## 1 Introduction

Major objectives of the CSELR are to improve the capacity and performance of the transport network and reduce congestion particularly in the CBD. Throughout the process I have tried with little success to have the project team and the Minister properly clarify and document the assumptions used in the analysis of whether this objective will be achieved. The EIS has no proper statement of the assumptions used and their applicability. Several key assumptions, while possibly justified in isolation, relate to idealised situations which are not always applicable. Some assumptions cannot be true at the same time.

The EIS states the figure of 9000 passengers per hour (the "design capacity") and then uses this in the context of meeting passenger demand. Nowhere is there an analysis of the "achievable capacity", nor on the impact of loading levels on other parameters such as journey time or on-time running.

Figure 3-11: 2021 AM Peak CSELR Boardings and Mode of Access by Light Rail Stop⁸⁶

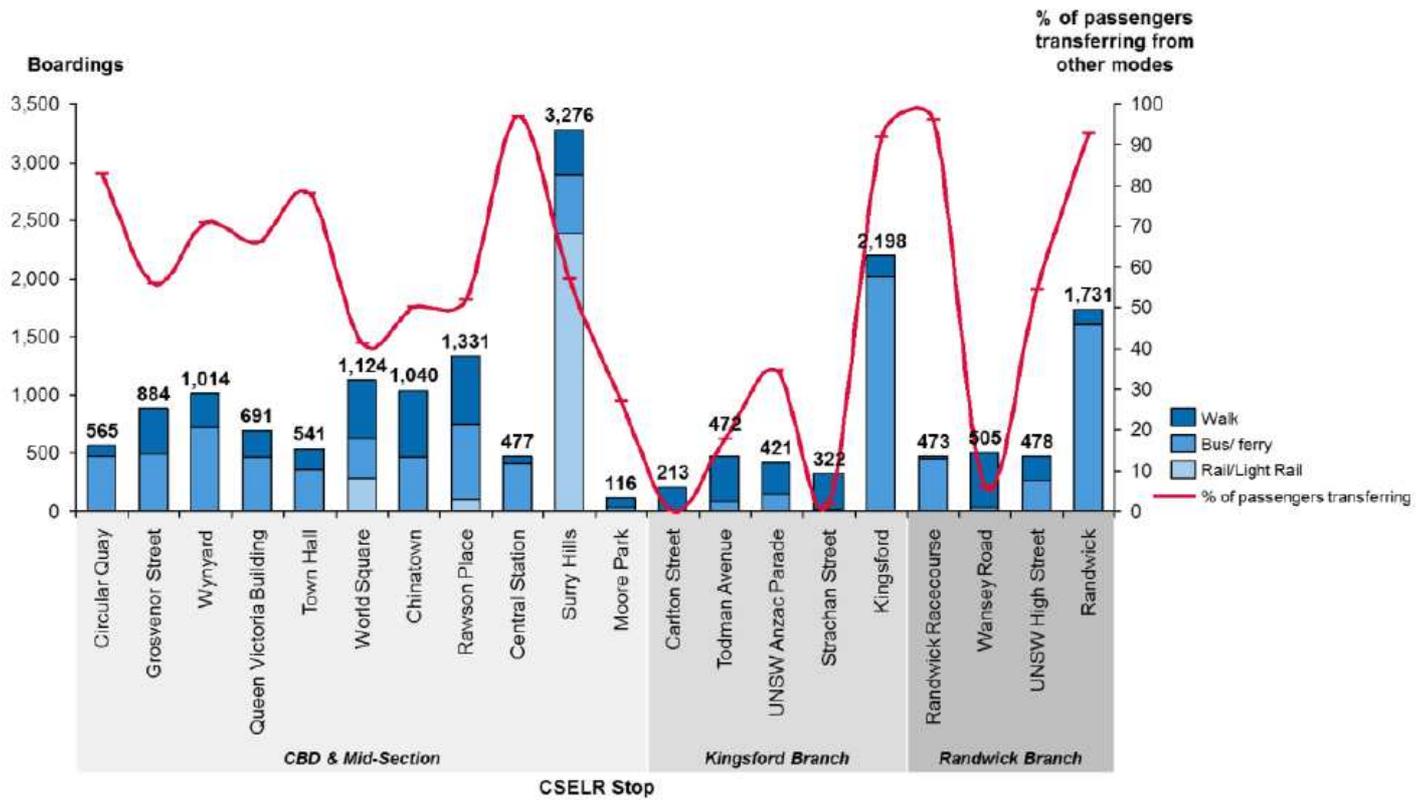
9.8 Technical paper 1 Figure 3-11: 2021 AM Peak CSELR Boardings and Mode of Access by Light Rail Stop, seems to be incorrect for Surry Hills.

Figure 3-12: 2021 Inbound AM Peak CSELR Line Load and Capacity Consumed⁸⁹

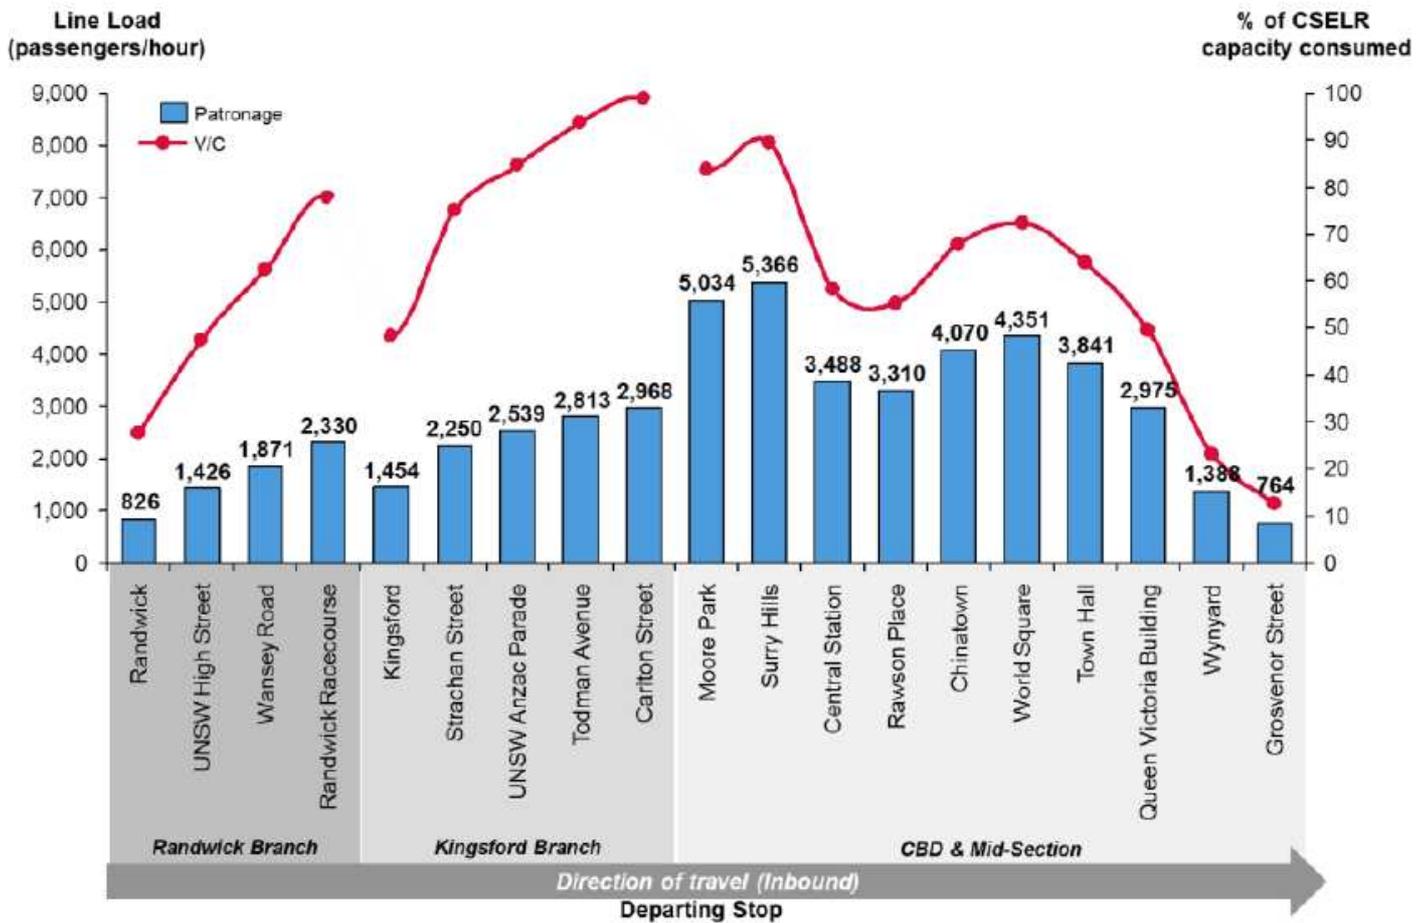
Technical paper 1 Figure 3-12: 2021 Inbound AM Peak CSELR Line Load and Capacity Consumed, shows that the initial AM inbound passenger capacity approaches or exceeds 90% at more than one stop. Outbound AM traffic also reaches 80%. Variability in passengers arriving at the stops is likely to be high as many are transferring from buses. Significant numbers of waiting passengers will be unable to board some services decreasing reliability from a user perspective. It will also increase dwell times resulting in bunching, adversely affecting on-time running.
